**Re: NMCC Expansion  
4901 Lang Ave. NE  
Conceptual Traffic Circulation Layout for DRB Approval  
Engineer's Stamp 08-24-22 (D17-D003V1)**

**Reference: NMCC Expansion – 4901 Lang Ave. NE Traffic Circulation Layout (DIV-D003V1)  
Comment Response Letter, 4th Submittal**

DESIGN REVIEW COMMITTEE	CITY ENGINEER APPROVAL	ZONE MAP NO.	D-17-Z
		CITY PROJECT NO.	PR-2022-007588
		APPLICATION NO.	SI-2022-01858
		SHEET NO.	C-102

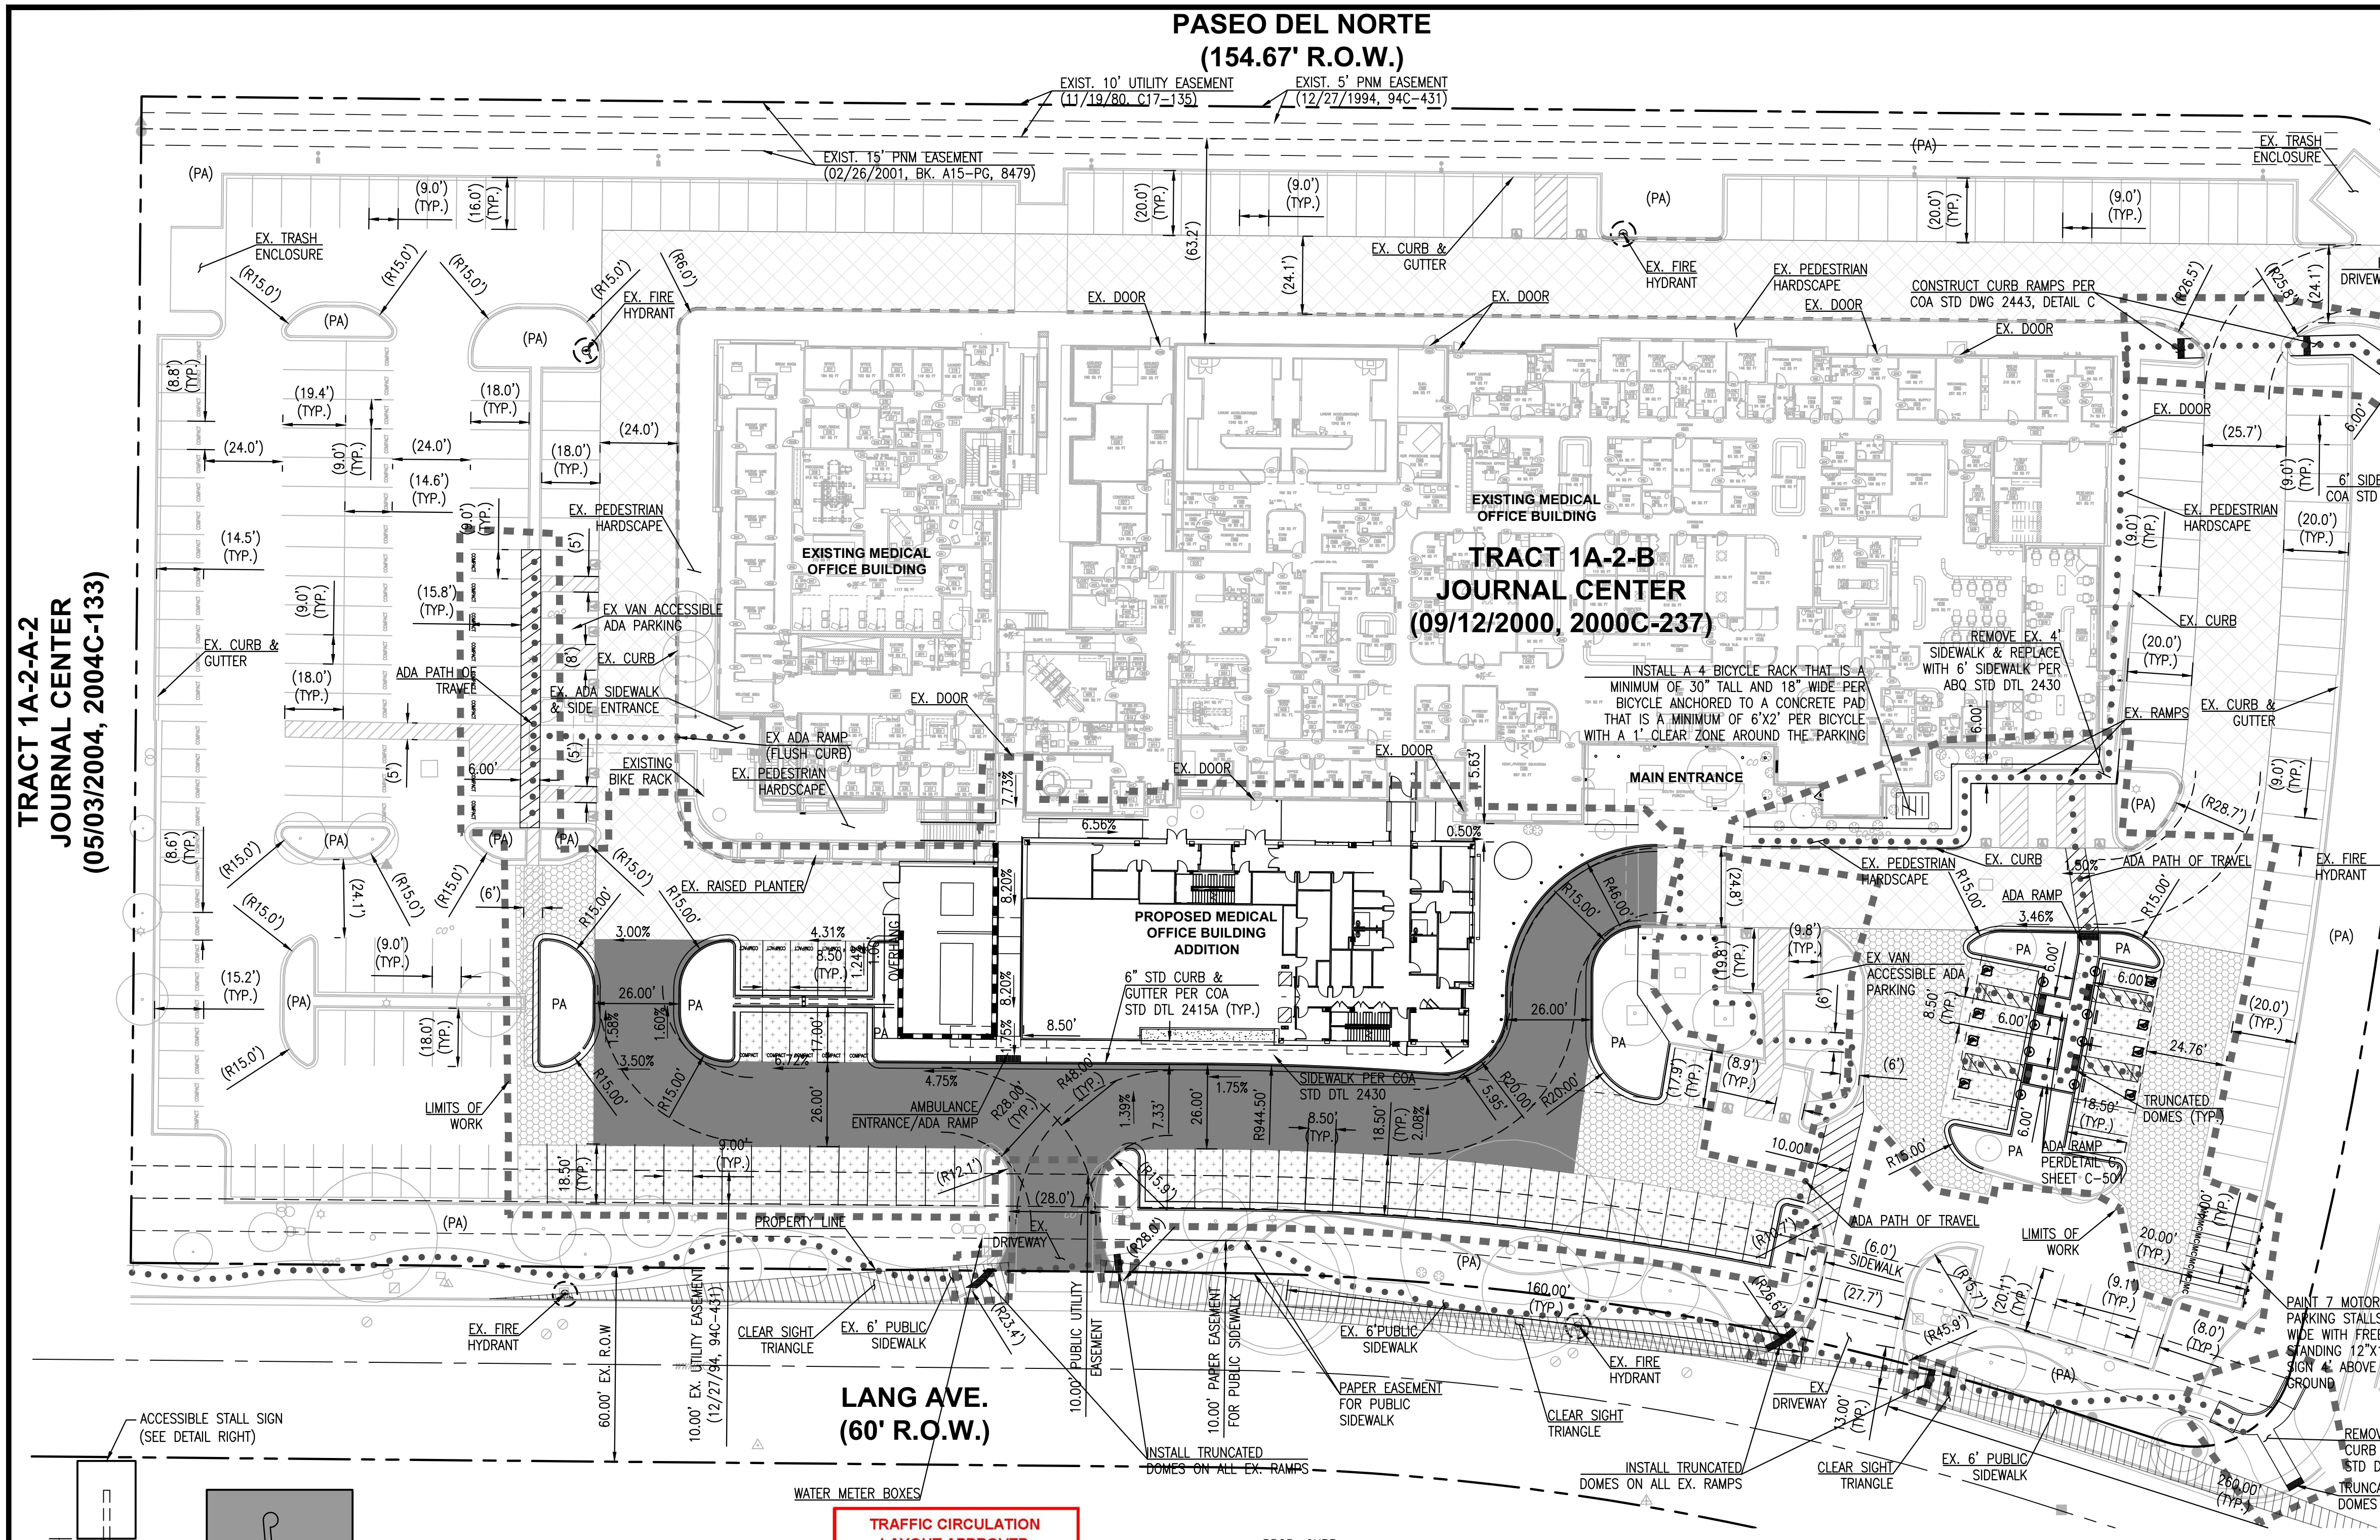
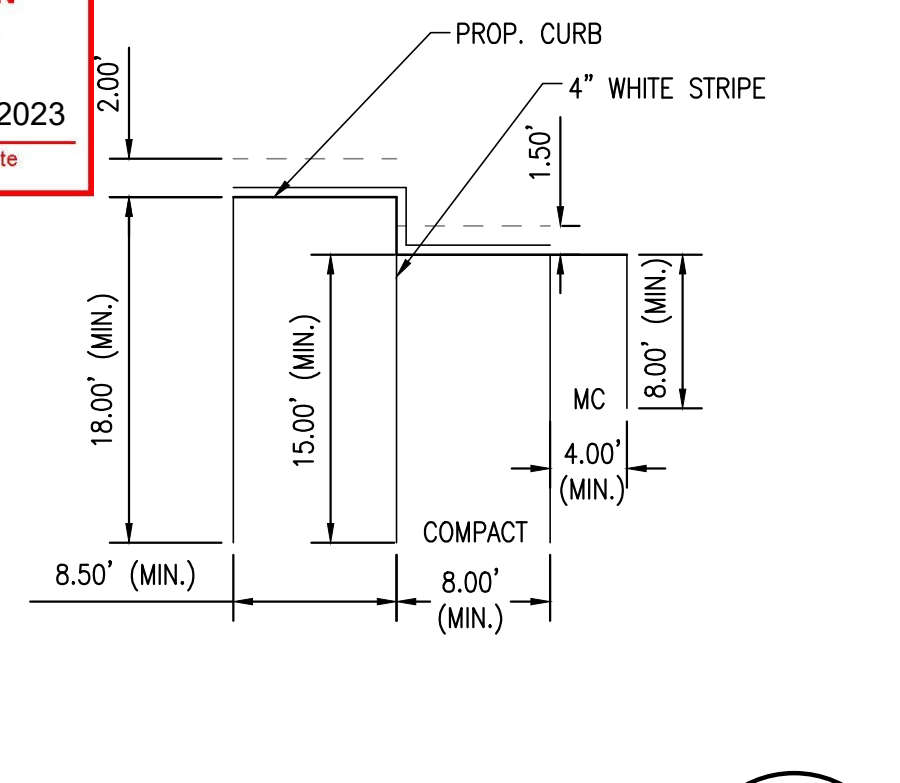
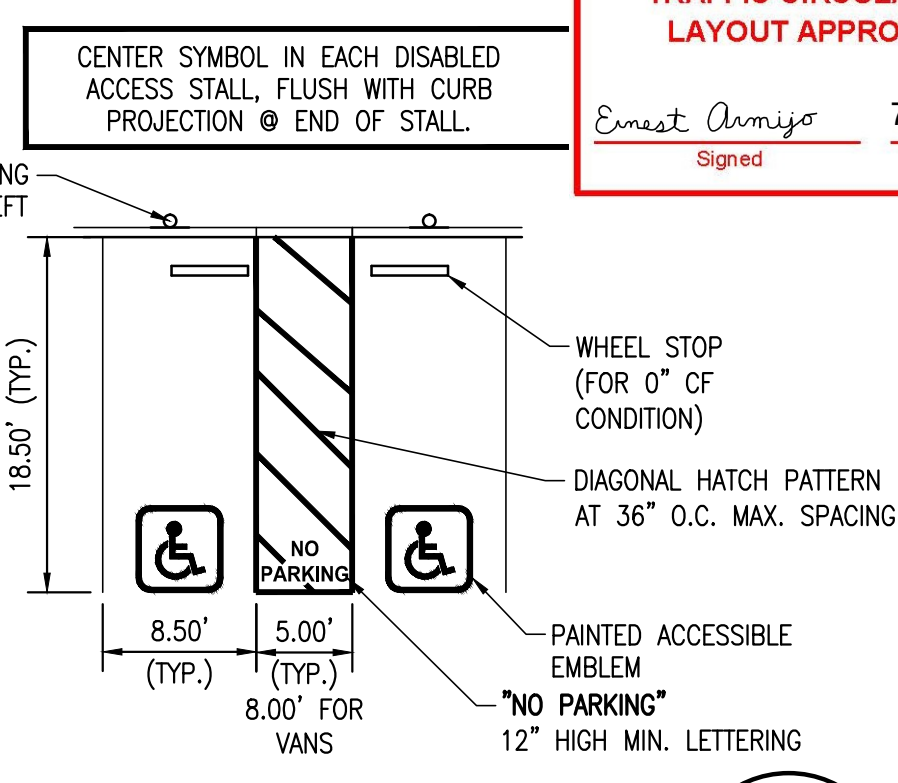
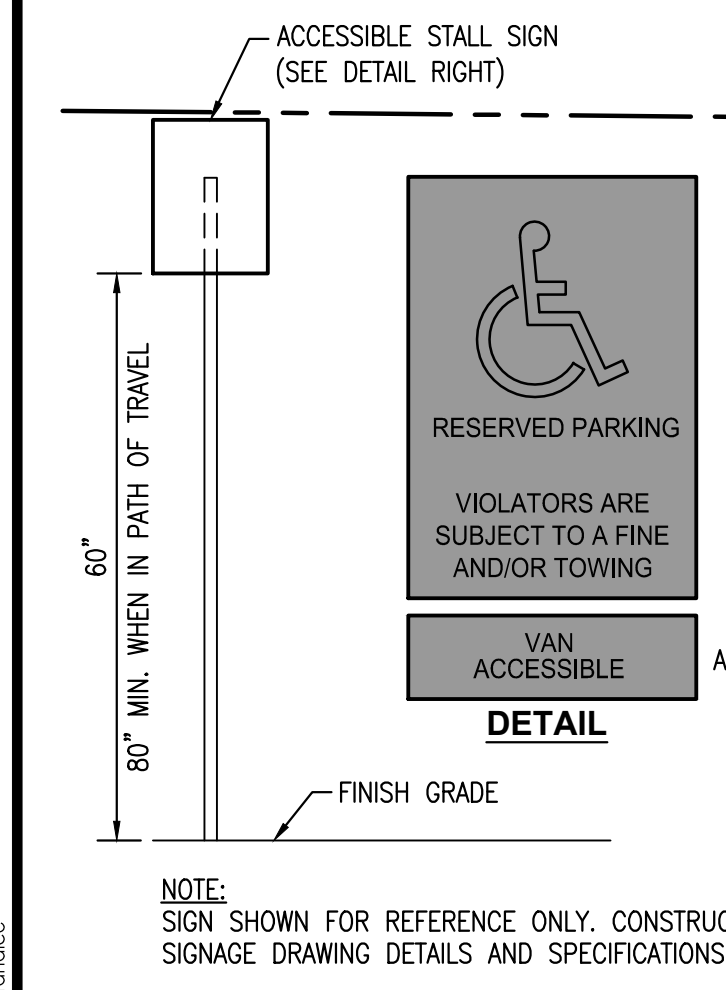
1. Please indicate how many parking spaces will be on the site after new expansion construction.

2. Please define ADA pathways by labeling ramps, flush pavement, and provide all proposed ramps details. Call out ramps with a keynote on the site plan too.

3. Truncated Domes must be installed on all ADA ramps at the driveway accesses.

4. The ramp at the corner of Lang Ave. and Headline Blvd. needs to be updated to current ADA city standard and have a truncated domes.

5. The ADA accessible spaces must include an access aisle. Van accessible aisles should have 8ft wide; all others should be 5ft wide.

6. The pavement marking “MC” should be shown opposite direction for motorcycles entering the parking space.

7. Please provide details for all the proposed signage and pavement marking.

*Response: Please refer to the parking tabulation near the bottom right corner of the C-101 sheet. Provided motorcycle and van accessible parking stalls were added.*

*Response: Notes have been added to both the exhibit and site plan. Ramp are provided on sheet C-501.*

*Response: Truncated Domes were added to all ADA ramps at the driveway accesses.*

*Response: A note was added to remove the existing ramp and construct a new ramp per COA standard detail 2444. Truncated domes are now shown as well.*

*Response: All existing and proposed ADA accessible spaces have an access aisle and are identified. 2 existing van accessible parking spaces were identified (1 at the main entrance and another at the western entrance).*

*Response: “MC” is now shown on the pavement of each motorcycle stall.*

*Response: Details A was revised to include motorcycle parking striping, Details B & C show Van accessible signage and striping information. All other signage and striping was already accounted for in the plans.*
